Application by North Somerset District Council for Portishead Branch Line – MetroWest Phase 1
The Examining Authority’s Further written questions and requests for information (ExQ2)
Issued on 26 January 2021

ExQ2: [26 January 2021]**Responses due by Deadline 5: Tuesday 16 February 2021**

Drawing
PORTISHEAD STATION CAR PARK
LAYOUT, LANDSCAPING AND NEW
BOULEVARD AND ACCESS PLAN
SHEET 2 OF 3

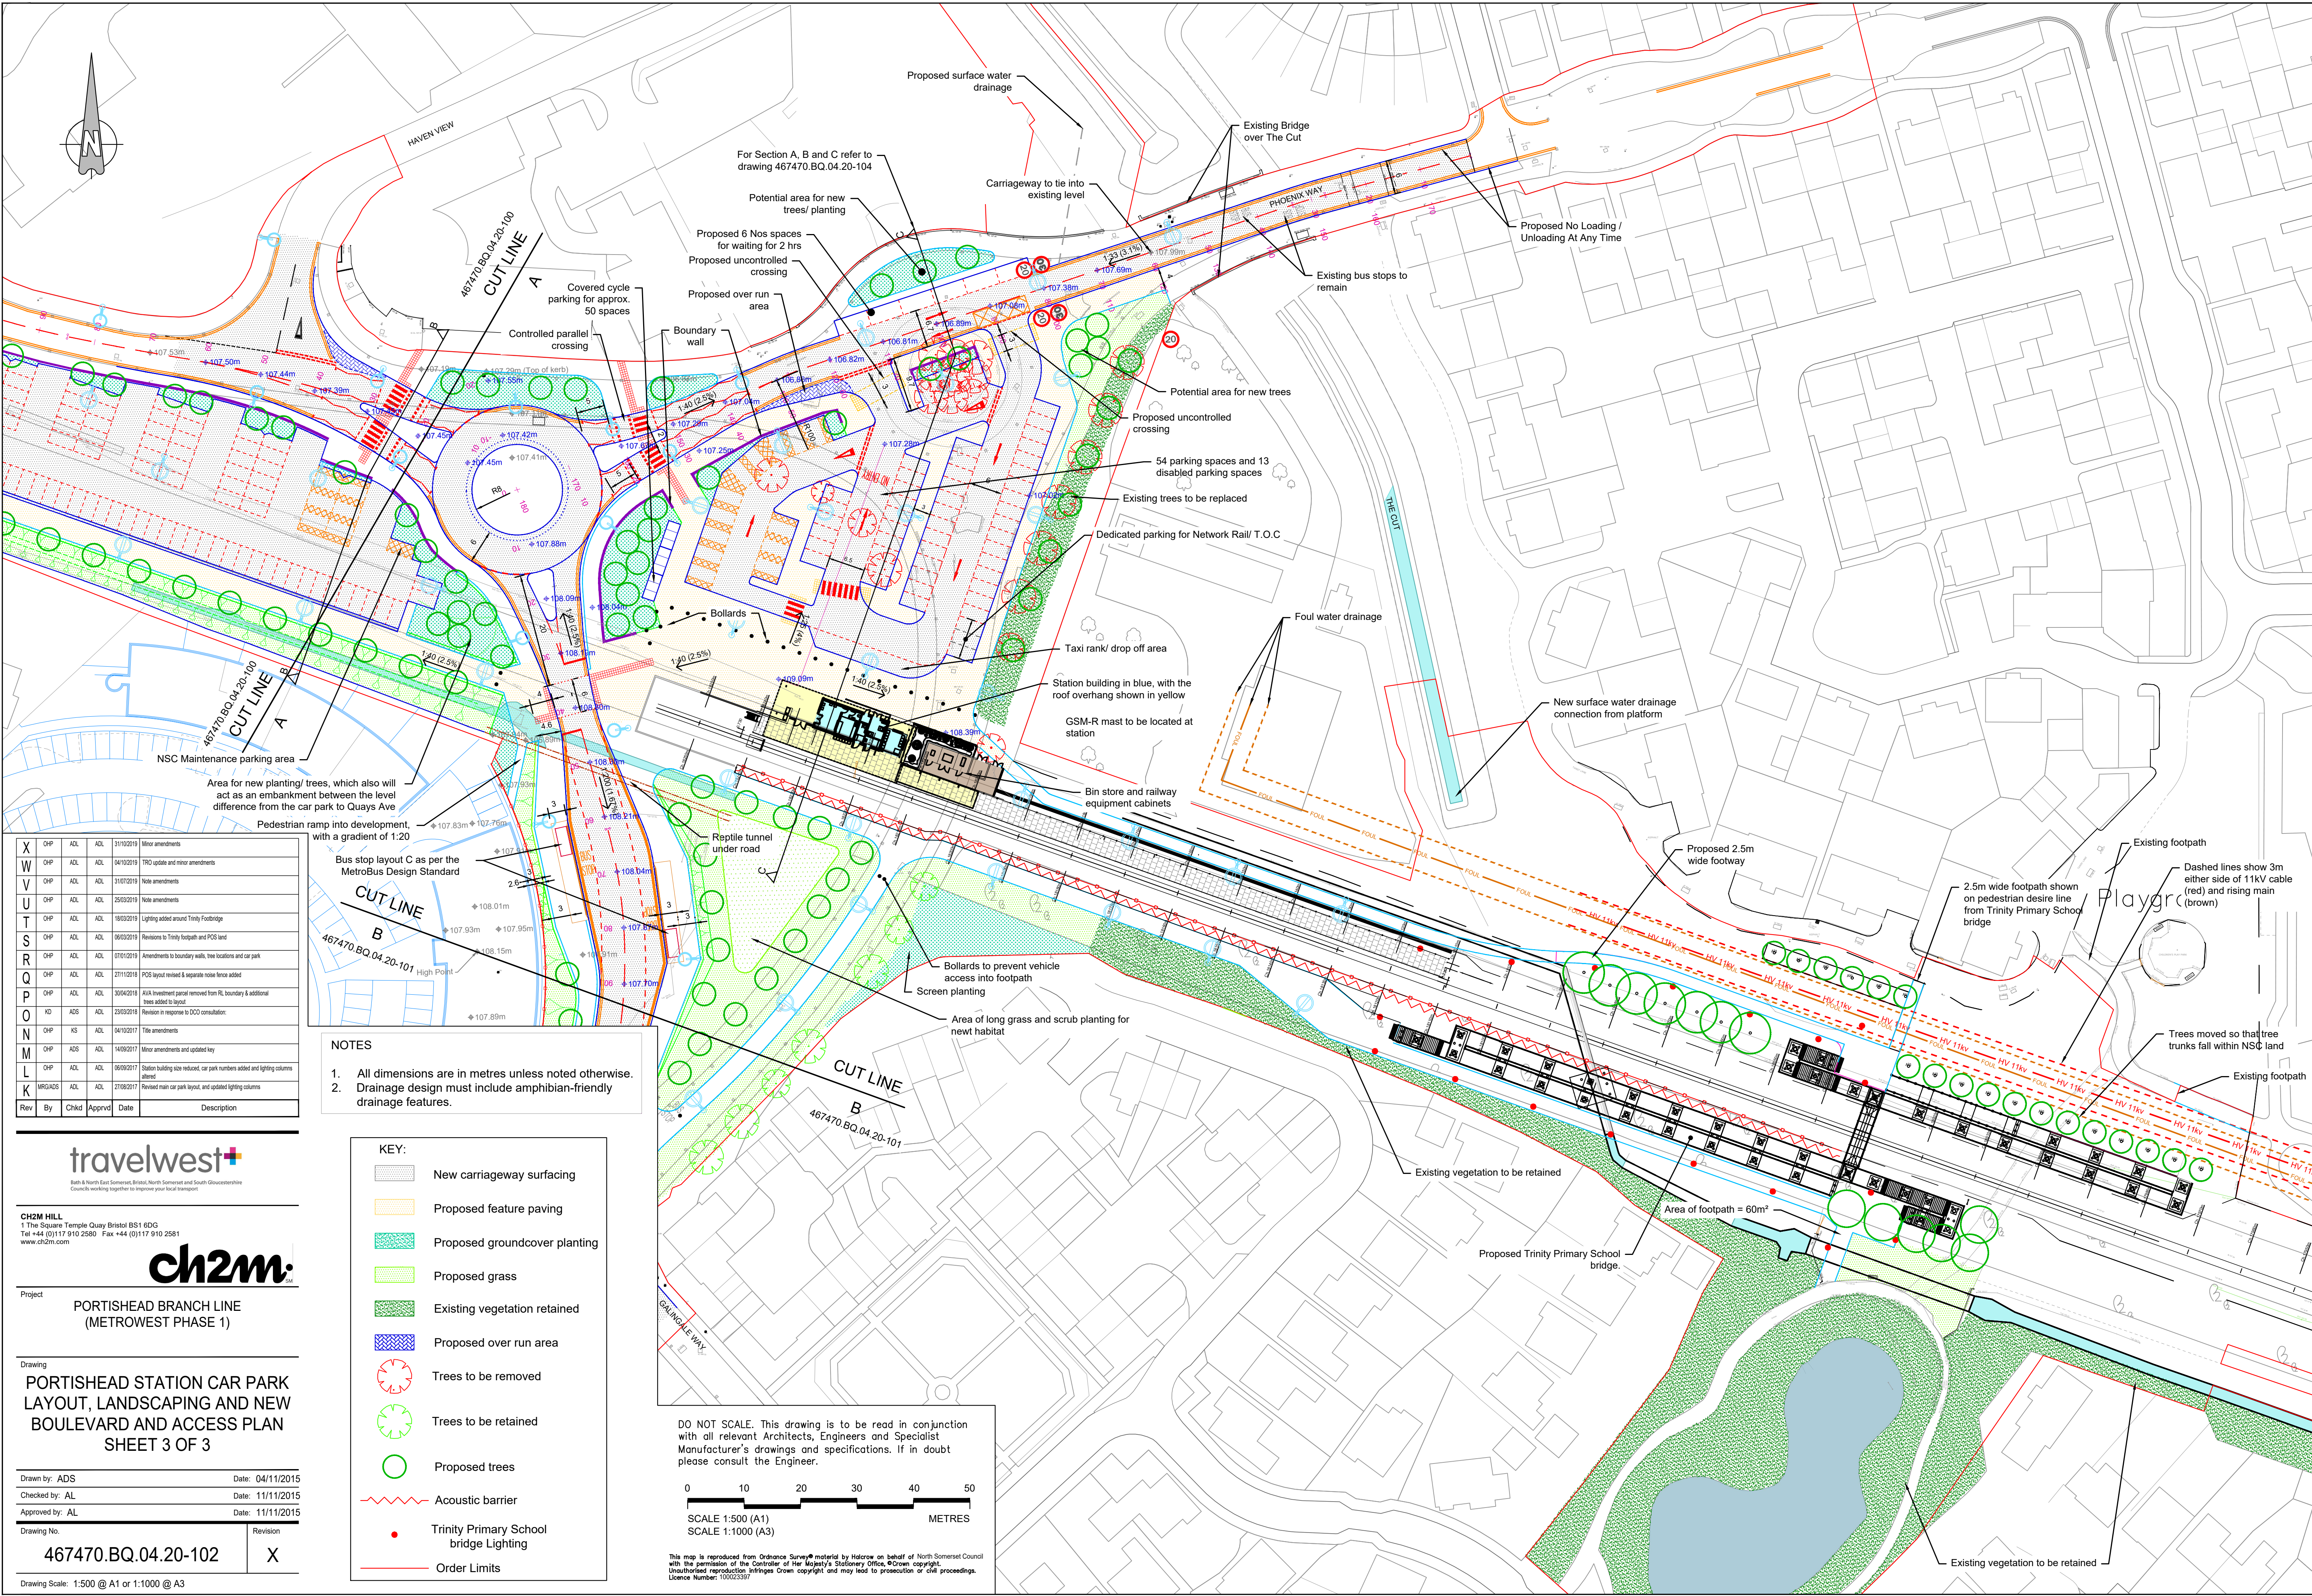
CA .2.1	<i>Crown Land</i> The Applicant	Provide an update on the progress made regarding obtaining Crown consent and whether this is likely to be achieved before the close of the Examination.
DE Design		
DE .2.1	<i>Work No 5</i> <i>Portishead Station</i> The Applicant	ExQ1 answer DE.1.5 [REP2-013] states that the GSM-R mast antenna cannot be attached to the station building for maintenance and safety reasons. If proposed as a separate structure, how would its visual impact be minimised?
DE .2.2	<i>Work no 5</i> <i>Portishead Station</i>	Harbour Residential Care Centre which faces the Quays Avenue/ Harbour Road roundabout is not currently shown on the existing or proposed plans, in particular Portishead Station car park layout, landscaping and new boulevard and access plans 467470.BQ.04.20-100 & 102 Rev X. In order to

ExQ2	Question to:	Question
	The Applicant	enable an accurate assessment of its relationship to the proposed station can the Applicant provide revised layout plans to include the care home building.
DE .2.3	<i>Work no 5 Portishead Station</i> The Applicant	The Applicant [REP4-021] and NSDC [REP4-042] have indicated that the most appropriate energy efficiency/ micro generation measures would be to install solar panels on the roof of the station building. The Applicant states that they will discuss the potential for such provision with the relevant planning authority, Network Rail and the Train Operating Company. Provide an update on such discussions, a drawing to indicate the location/ extent of such solar panels, and state how such measures can be specifically secured within the DCO – would an additional requirement necessary?
DE .2.4	<i>Work No 7 Trinity Footbridge</i> The Applicant	Provide a site location plan of the footbridge shown in the photographs at REP4-010.
